11 May 2021

Your Ref: SSD-6966-MOD-1

Advice on Response to Submissions – Barangaroo Building R5 Mod 1 Design Amendments – SSD-6966-MOD-1

1. UPDATED LEVEL'S FFL
2. UPDATED PODIUM FACADE
3. UPDATED AWNING DETAILS
4. LOWERED LMR HEIGHT
5. ADDED AWNING
6. ADDED 2 FACADE MODULES
7. UPDATED AWNING DETAILS
8. UPDATED ENTRY VESTIBULE
9. OPAQUE PANEL ADDED

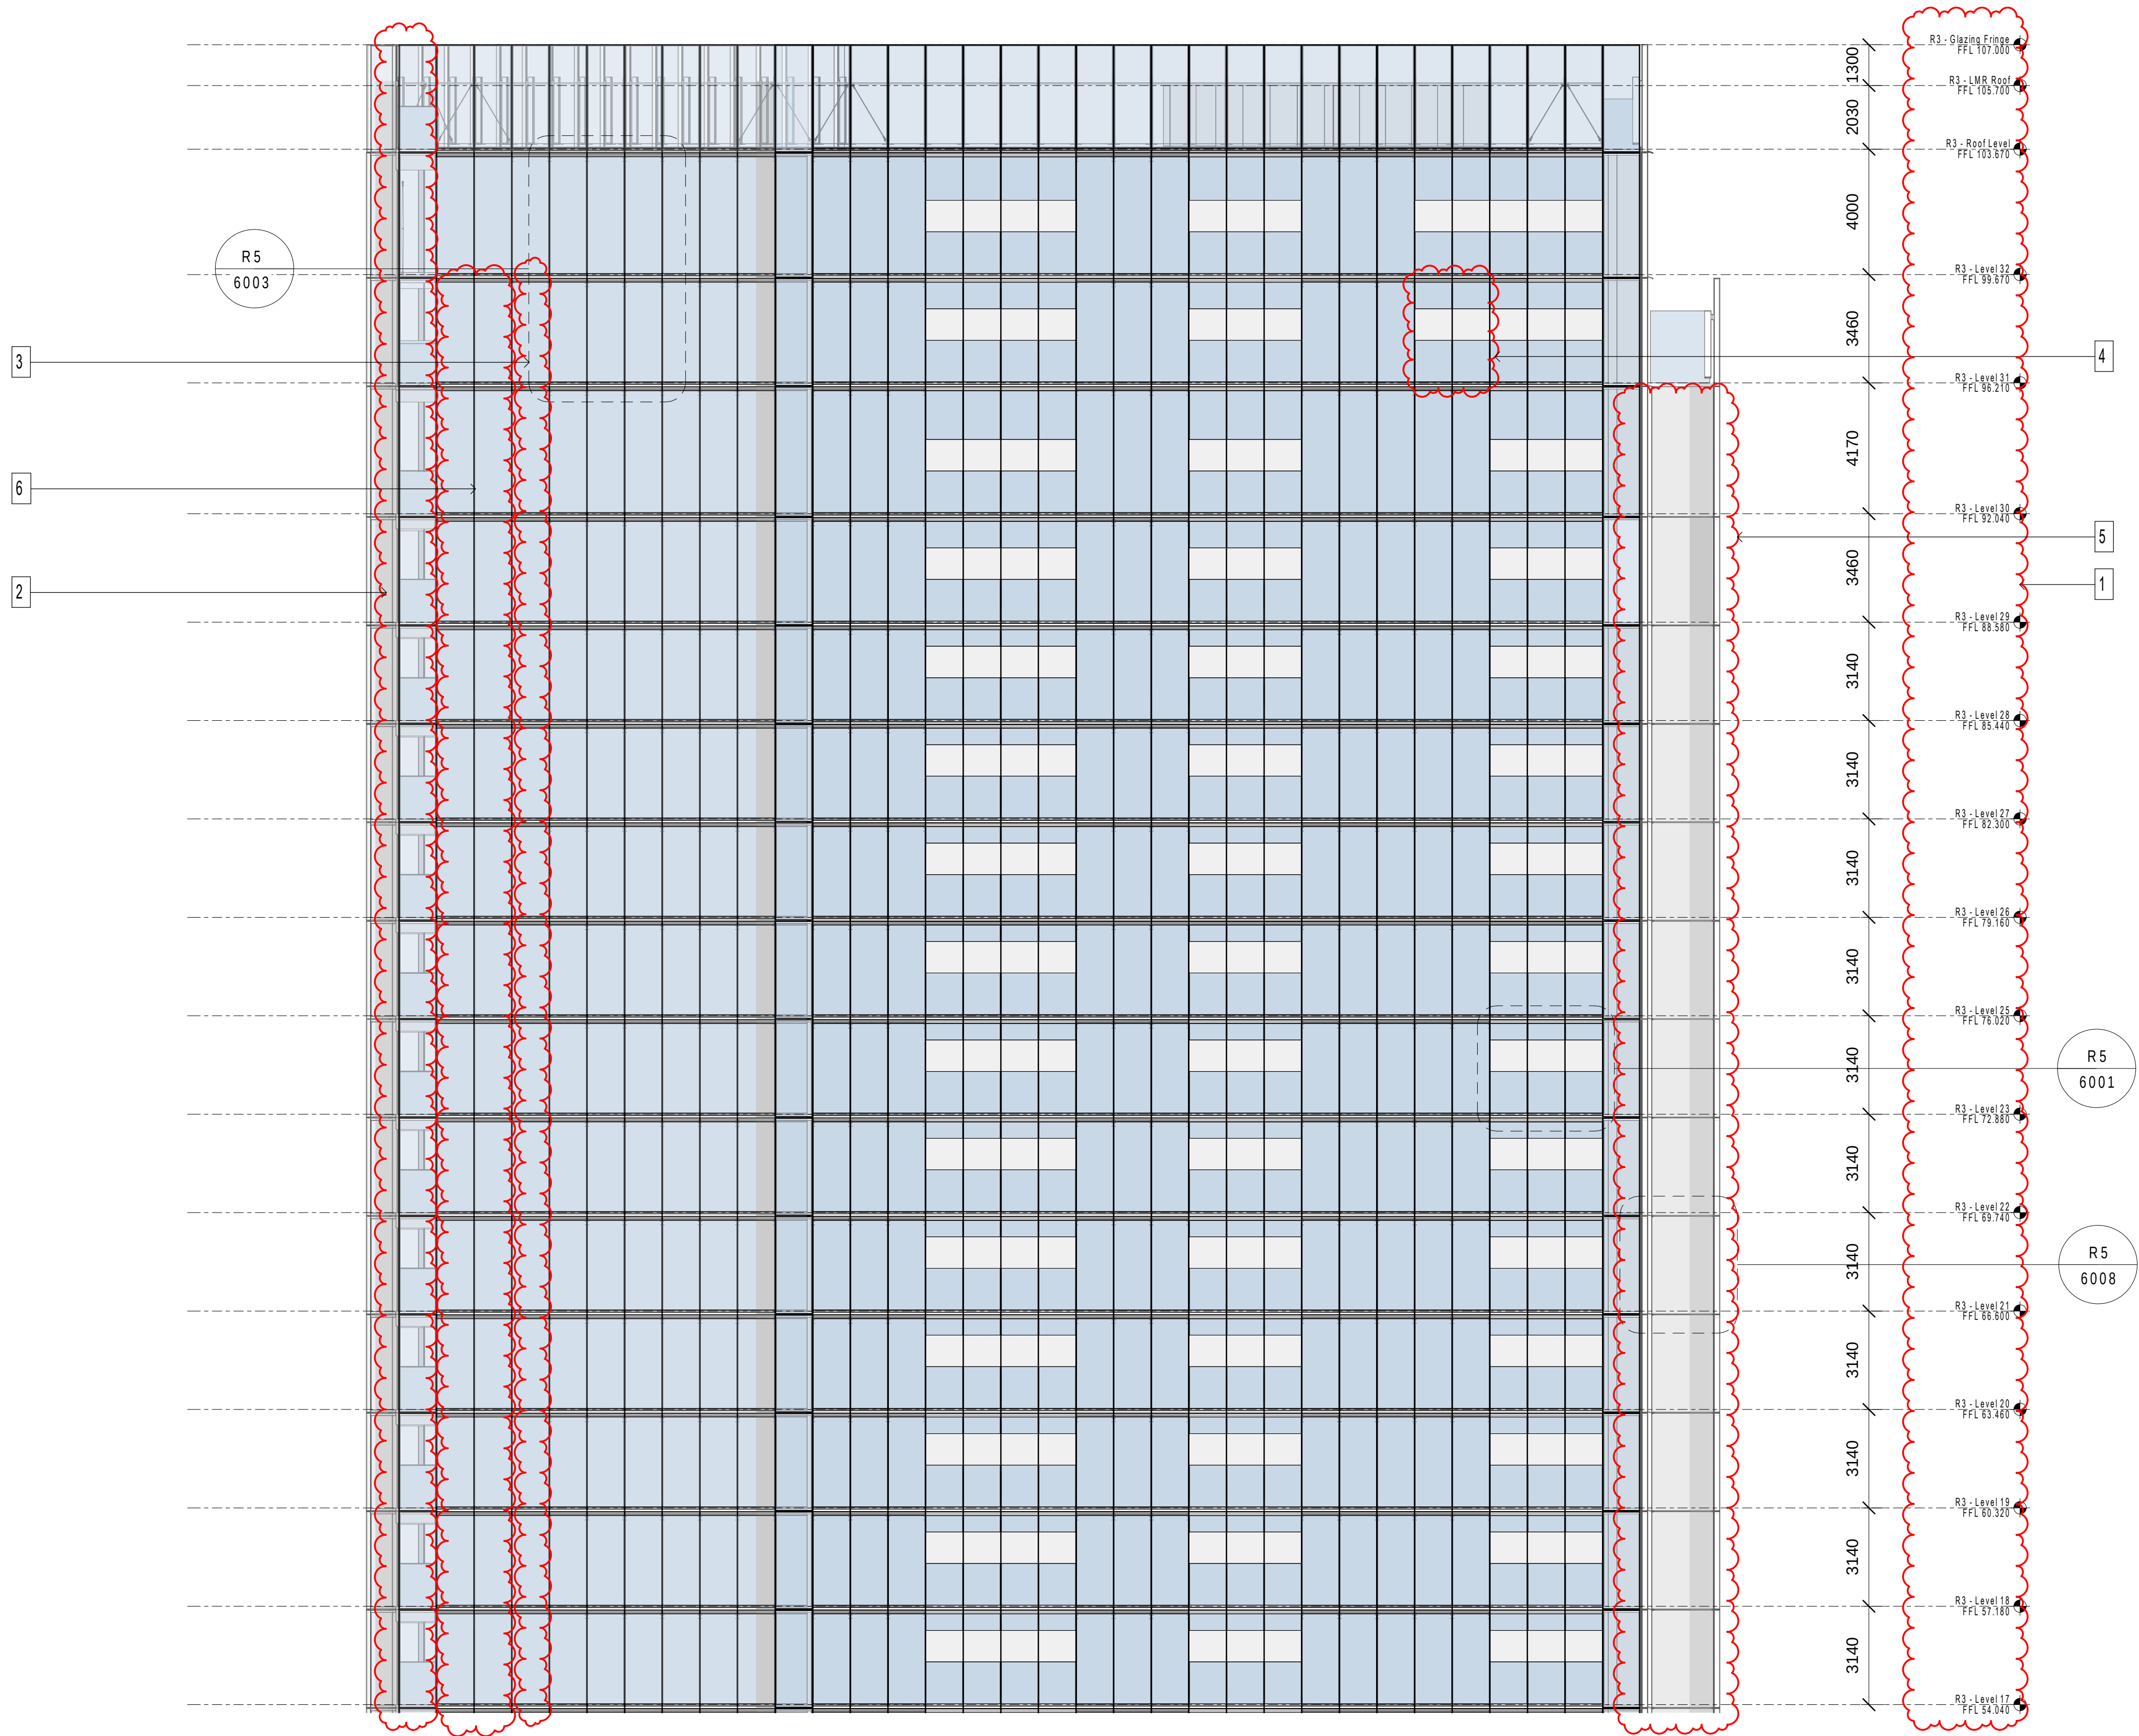
Noted as item 7 on the submitted elevations, it is not clear if the intention for full height glazed facades are for wintergardens or an enclosed balcony (a room) as the elevation appear to show full height glazing.

Section 4.2.3.13 of the Sydney Development Control Plan 2012 notes that wind-affected balconies require at least 25% of the external face of the balcony to be permanently open however, it is not clear if this amended scheme achieves this. Detailed section drawings are recommended to be submitted to clarify the amount of enclosure to the balcony and how the habitable rooms behind the enclosed balcony can maintain adequate access to natural ventilation.
